THE TRAILS AT ASPEN RIDGE FILING NO.3
A SUBDIVISION OF TRACT C AND TRACT I OF THE TRAILS AT ASPEN RIDGE FILING NO.2 LOCATED IN THE WEST 1/2 OF SECTION 9,
TOWNSHIP 15 SOUTH, RANGE 65 WEST OF THE 6TH P.M.
EL PASO COUNTY, COLORADO
SHEET 1 OF 4

DATE: 8/20/21
 SHEET 1 OF 4
 PCD# SF-21-022

THE TRAILS AT ASPEN RIDGE FILING NO.3

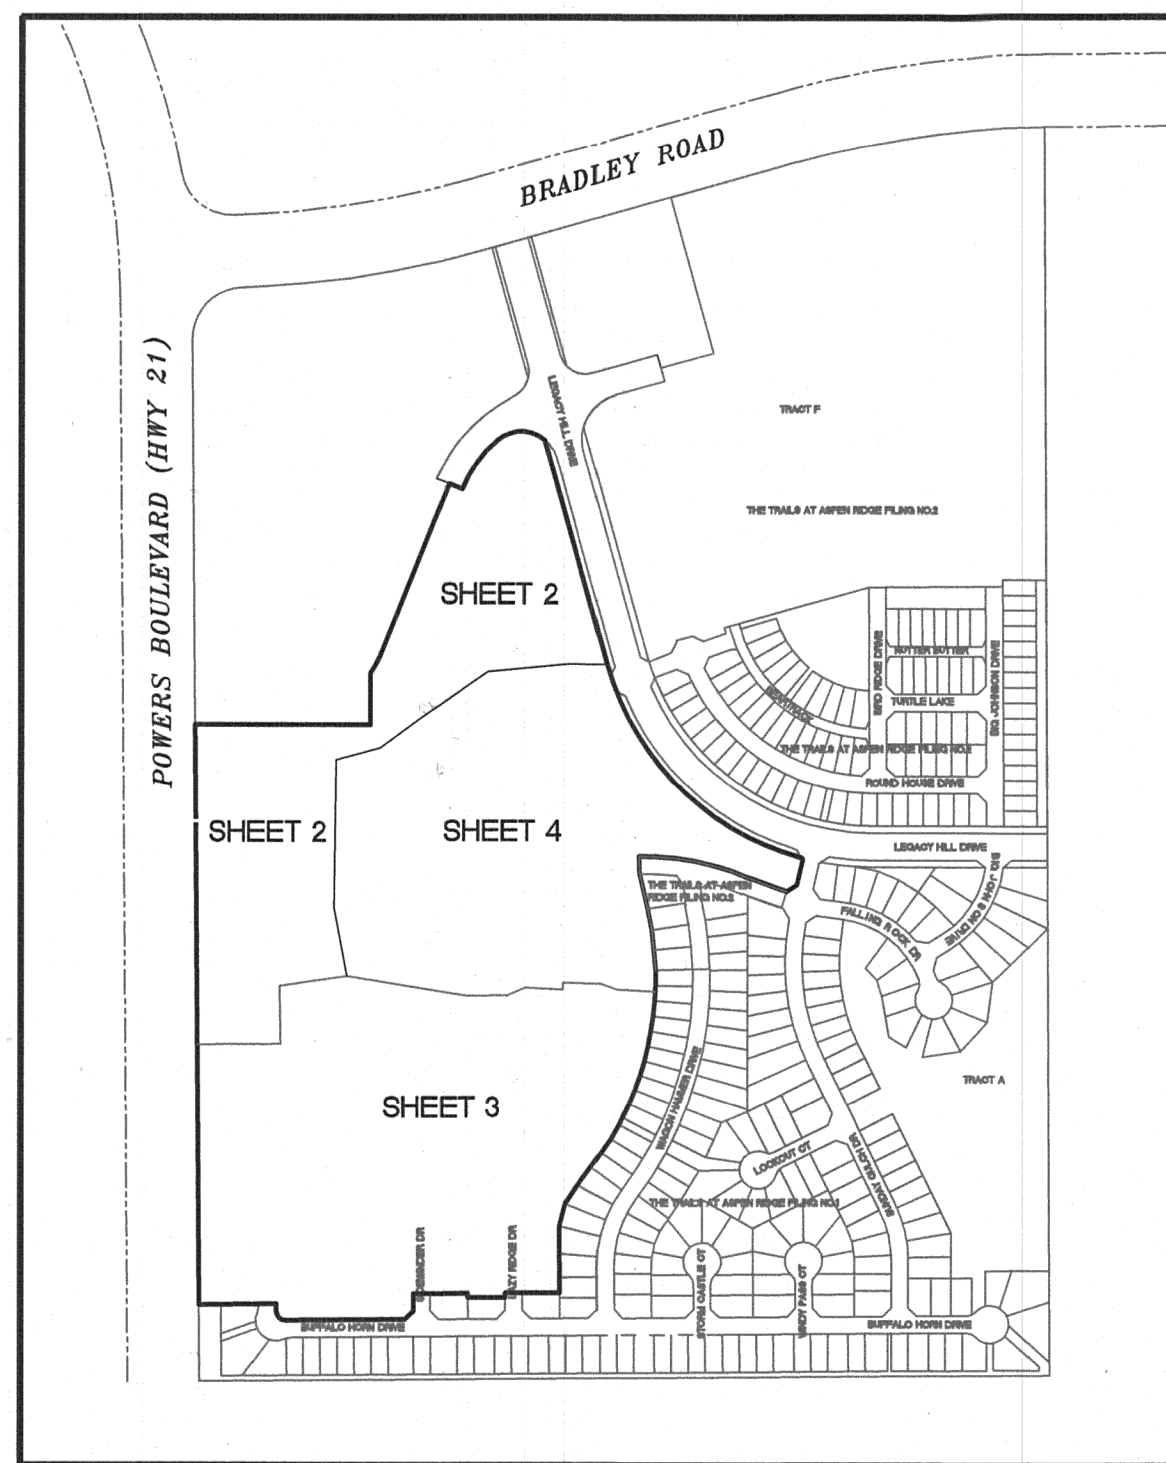
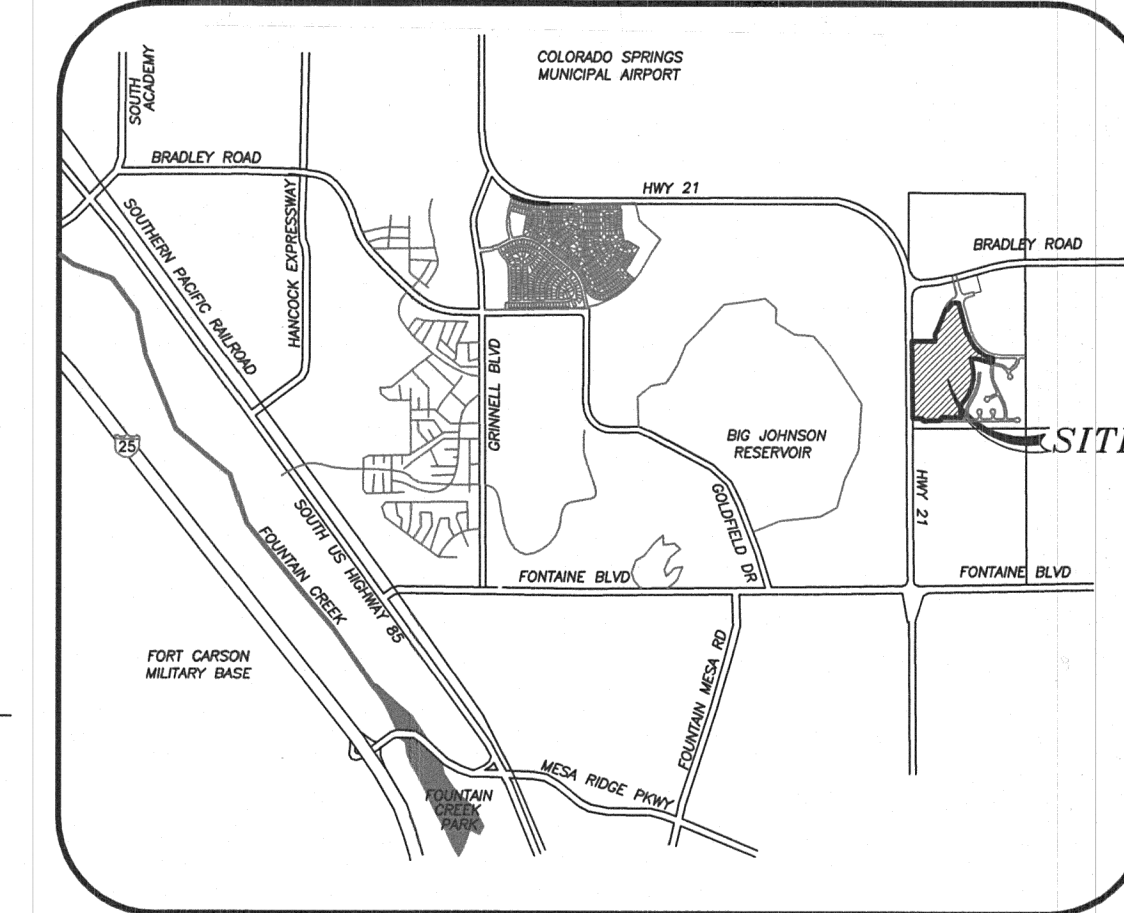
UNRESOLVED: Add the following plat note:
 -Mailboxes shall be installed in accordance with all El Paso County and United States Postal Service regulations.

- Tract A of this property is subject to a Private Detention Basin/Stormwater Quality BMP Maintenance Agreement and Easement as recorded at Reception No. _____ of the records of El Paso County, Waterview II Metropolitan District is responsible for maintenance of the subject drainage facilities.

-Coordinate with the geotech report regarding the geologic hazard note below. Customize as needed! The following lots have been found to be impacted by geologic hazards. Mitigation measures and a map of the hazard area can be found in the report (Title of report, generally from the Preliminary Plan filed by (author of the report) (date of report) in file (name of file and file number) available at the El Paso County Development Services Department:
 •Domeslope Creep: (name lots or location of area)
 •Rockfall Source:(name lots or location of area)
 •Rockfall Runout Zone:(name lots or location of area)
 •Potential High Groundwater:(name lots or location of area)
 •Other Hazard: _____

UNRESOLVED: The geotech showed potentially seasonal shallow groundwater area on Figure 6. If this is no longer applicable, provide a response to comments as such.
